From: [REDACTED]
Sent: 13 June 2022 11:19
To: Planning
Subject: Fwd: Planning Application 3/2022/0432 Feildens Arms Public House Mellor Brook

For the attention of Kathryn Hughes Planning Officer Planning Application 3/2022/0432

We wish to object to the proposed restructure of the Feildens Arms Public House

Proposed Block Plan © 1:100

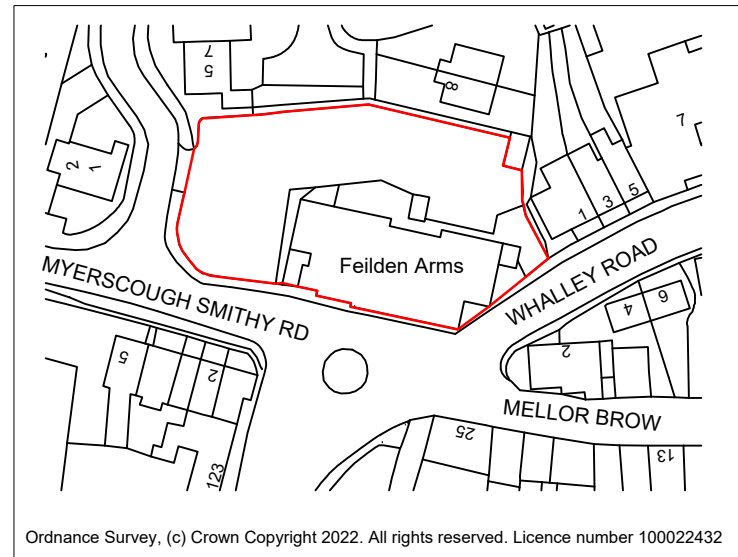
You only need to review from the papers presented with the application the present plan of the site against the proposed plan of the site

Parking places will be reduced by four

Not only that but the plans show the outside on which the extra seating is requested will further reduce the car parking area space not maybe parking spaces but how vehicles will be able to drive into and out off those spaces The plan submitted does not show the full site including the parking area therefore it is impossible for any planning authority or indeed highway authority to properly review this aspect

This proposed change will reduce the number of parking spaces on the site to 30(thirty)

Proposed rear elevation

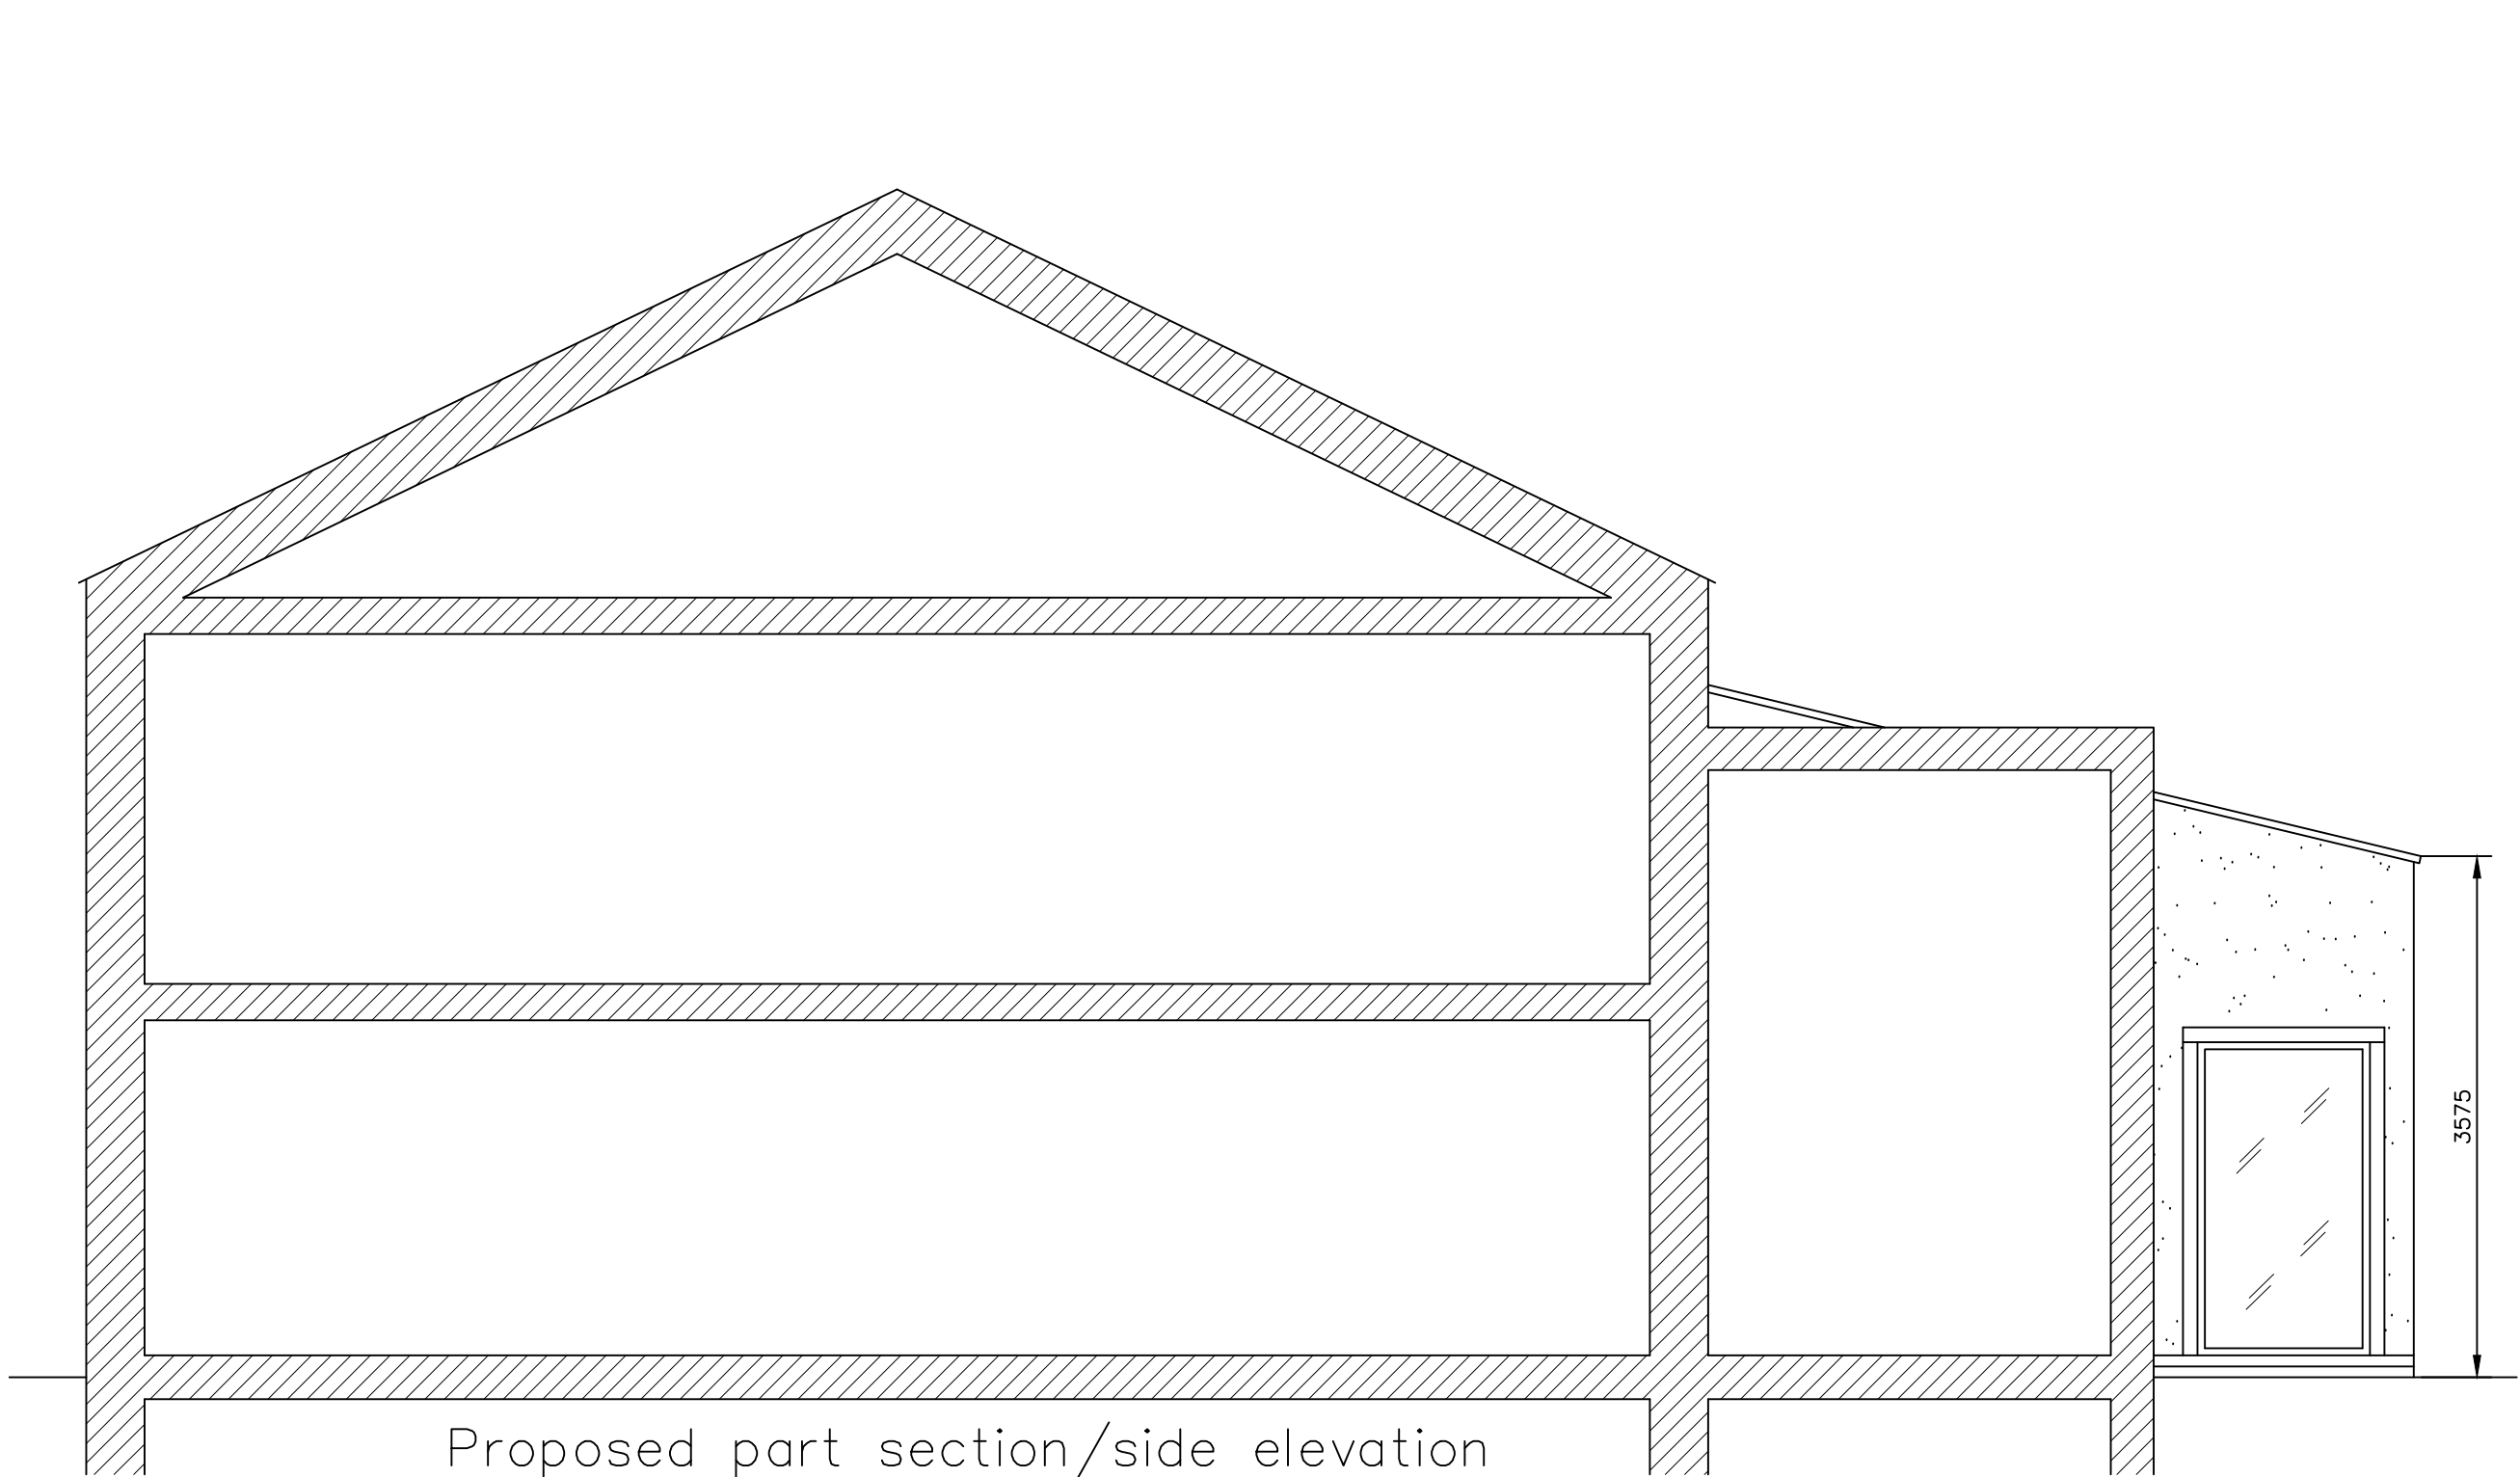
There is also the prospect of a substantial increase in noise from inside the property with the construction of glass open doorways

Again these doors open to a large number of residential properties

Increasing the potential noise levels from inside the building outdoors

PROPOSED GROUND FLOOR PLAN

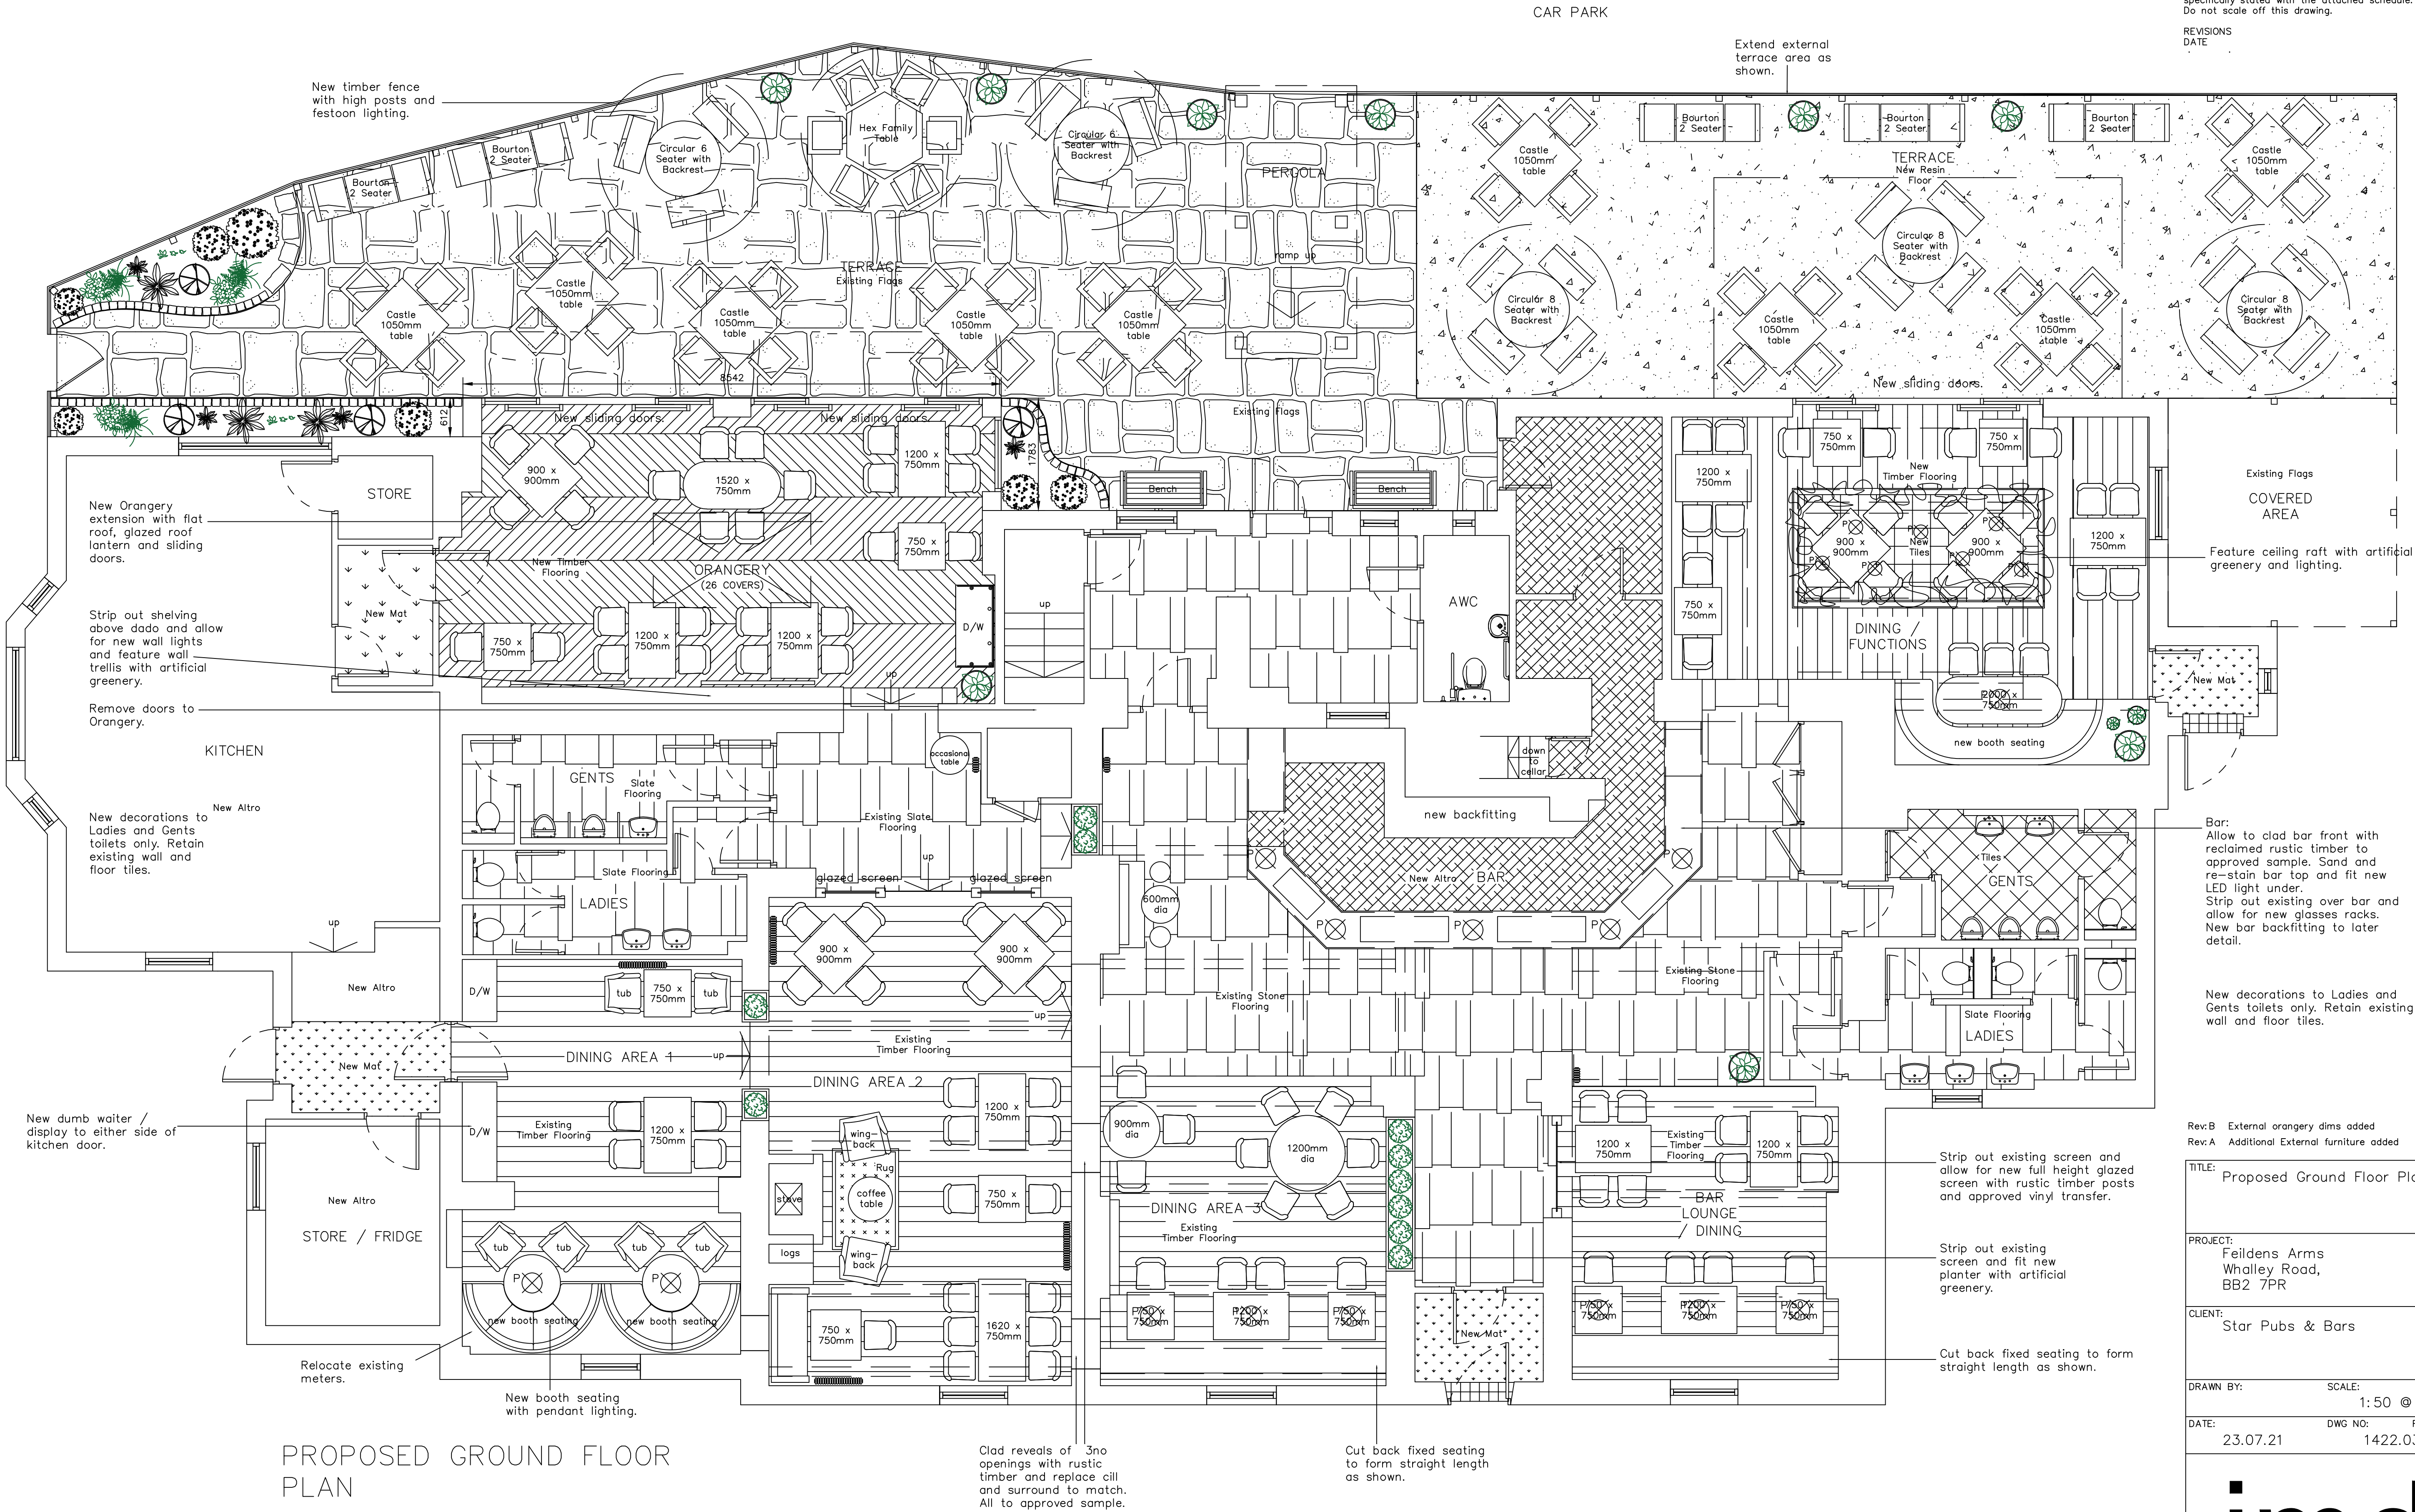
Noise~ It is proposed to increase the number of covers INSIDE 96 to 127 OUTSIDE 30 to 92

A substantial increase OUTSIDE in an area surrounded by many residential properties

The increase in outdoor covers is by over 300%(30 to 92)
